From: Sarah Burrow <Sarah.Burrow@arun.gov.uk>
Sent: 21 February 2020 12:20
To: Finlay Gardner <Finlay.Gardner@arun.gov.uk>
Cc: Planning.Responses <Planning.Responses@arun.gov.uk>
Subject: RE: BN/100/19/HH- Orchard End Highground Lane

101 - Proposed Surface Water Drainage

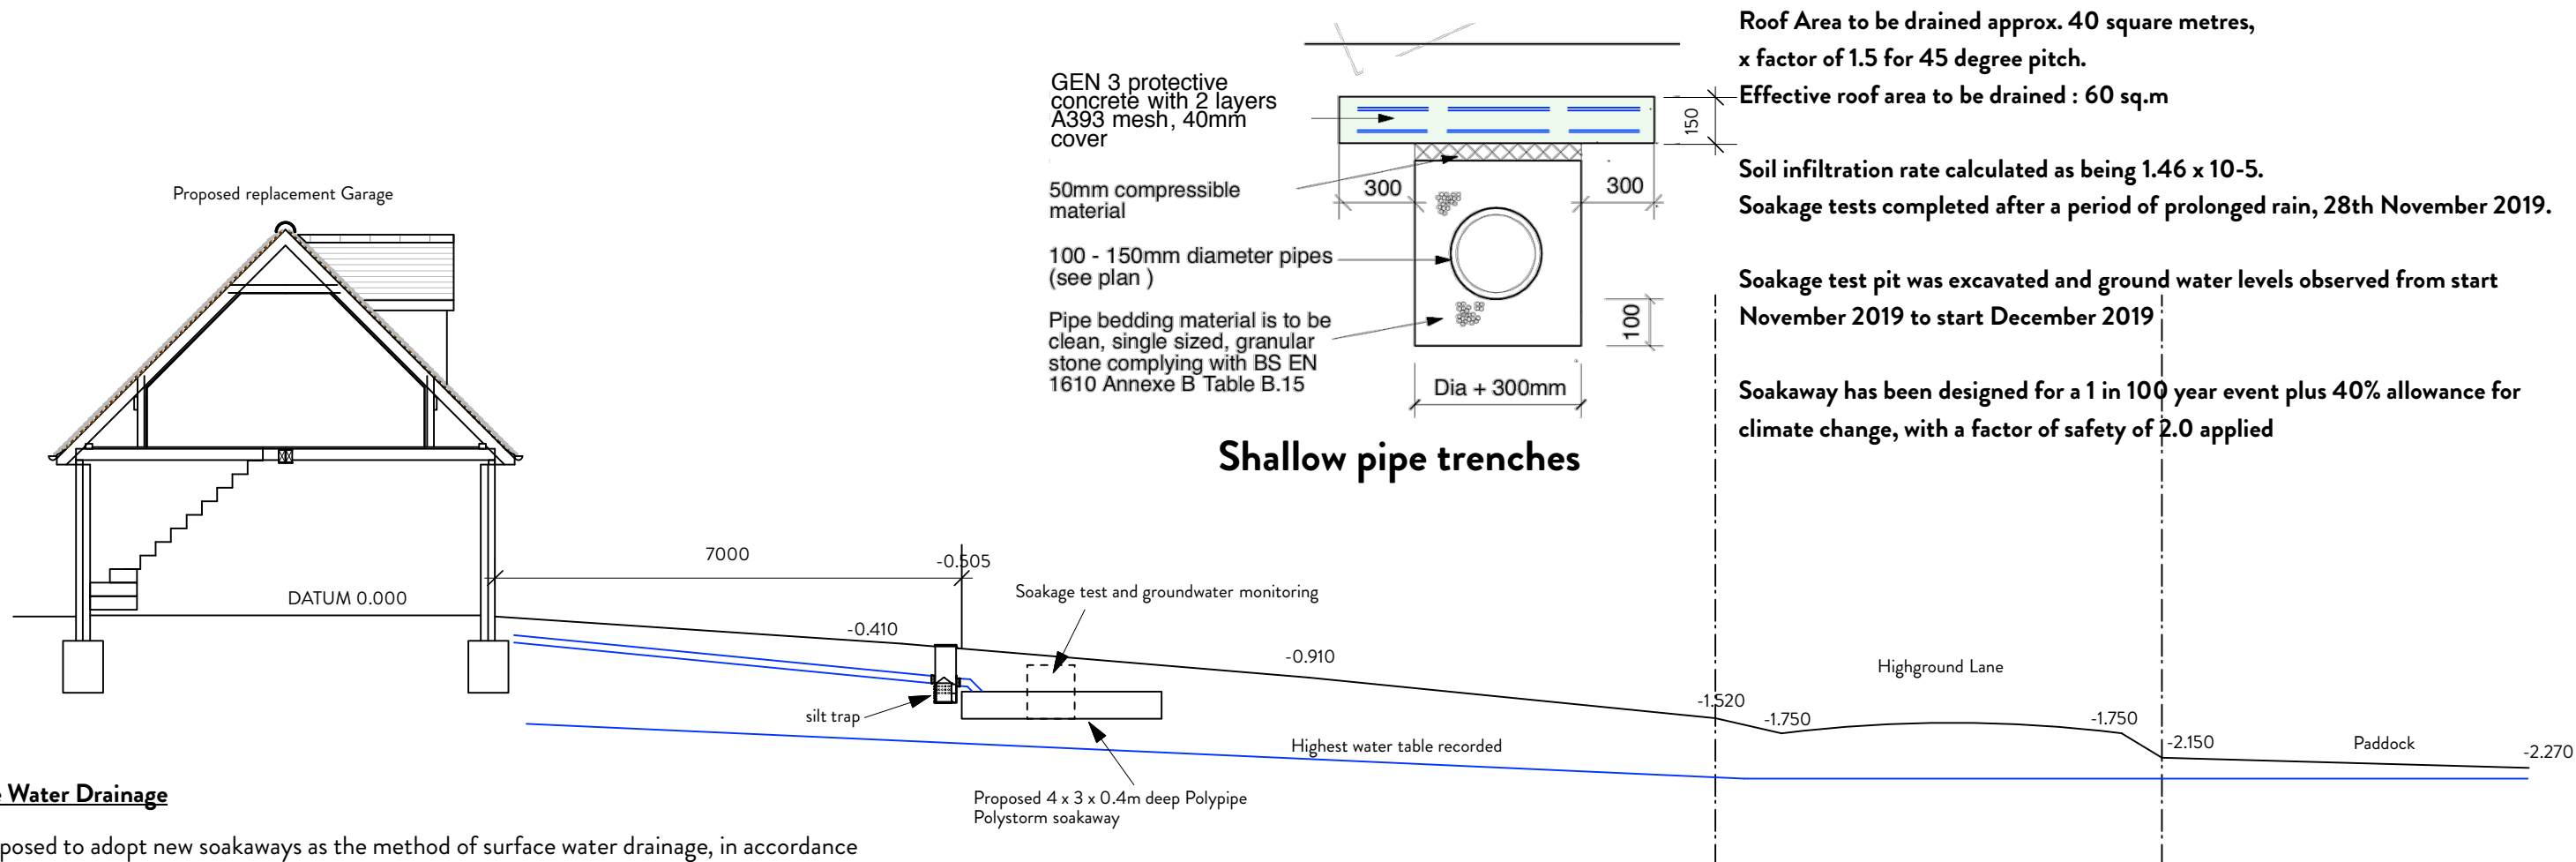
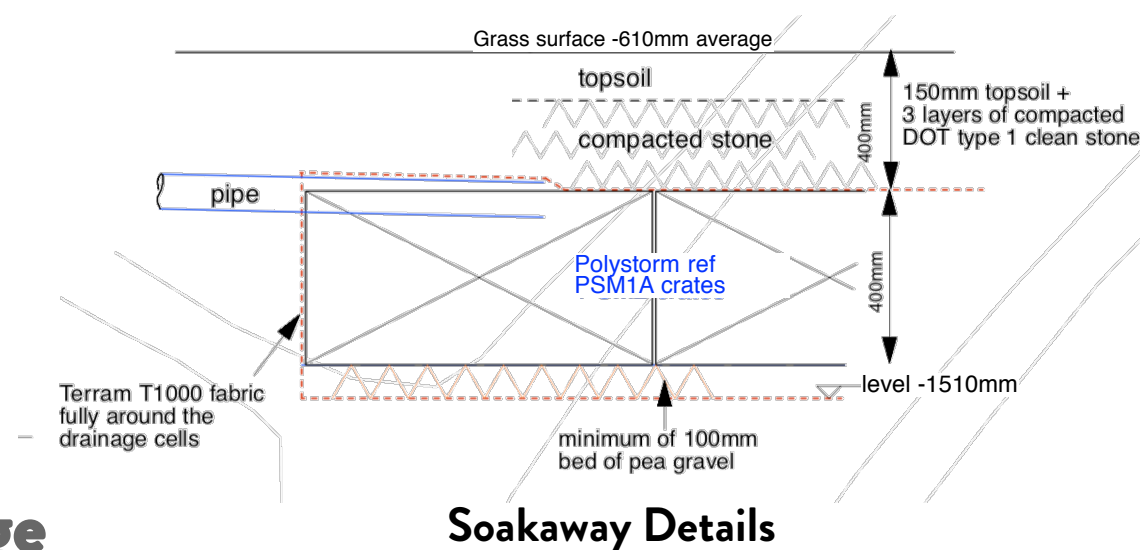
1. We do not normally approve schemes which account infiltration through the base of a soakaway in their design calculations. This is in accordance with BRE365 and due to the risk of silt reducing the infiltration rate. The applicant has included a silt trap so could make an argument for going through the base, however this will mean delegating the decision to the Principle Drainage Engineer which will cause further delays to the process. Alternatively they can adjust the calculations to show an 'Infiltration Coefficient Base' as zero.
2. Please show an indication of the location of the silt trap on the Proposed Section.
3. Please include a construction detail for the pipe bed and surround (I appreciate they have got a description but point 11 of the guidance notes states that this is required).

In addition, the soakaway needs to be designed for up to 1 in 100 year **+40%** and we would expect a silt trap and details of this to be shown. It is strongly advised that the applicant completes and submits a surface water drainage design checklist available at: <https://www.arun.gov.uk/download.cfm?doc=docm93ijm4n14067.pdf&ver=14313>

Yes that's fine. Please ask that the surface water drainage is constructed in accordance with these three documents (PL101C Orchard End, PL102A Orchard End, T-MD-43576_TR_MD1 (4m x 3m x 0.4m)).

Further to my email this morning, the designers have now re-run the soakaway calculations with the base coefficient set to 0 and this has resulted in a larger soakaway, so please find attached revised drawings and calculations. Please disregard the drawings I sent this morning.

102 - Proposed Surface Water Drainage

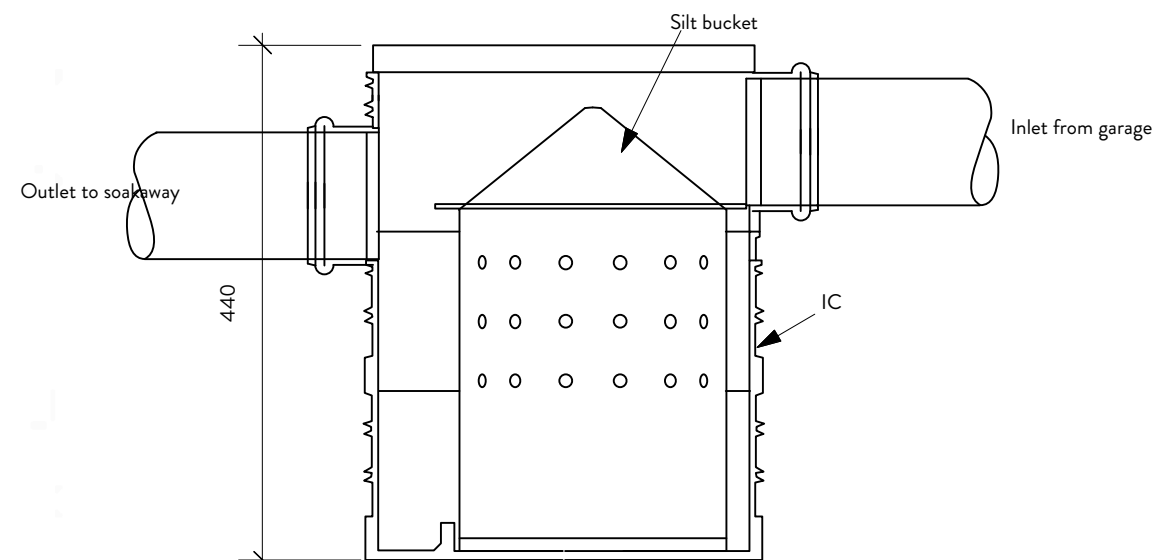
As a minimum (and following a brief review) we would require further detail of the groundwater monitoring and infiltration testing. I understand
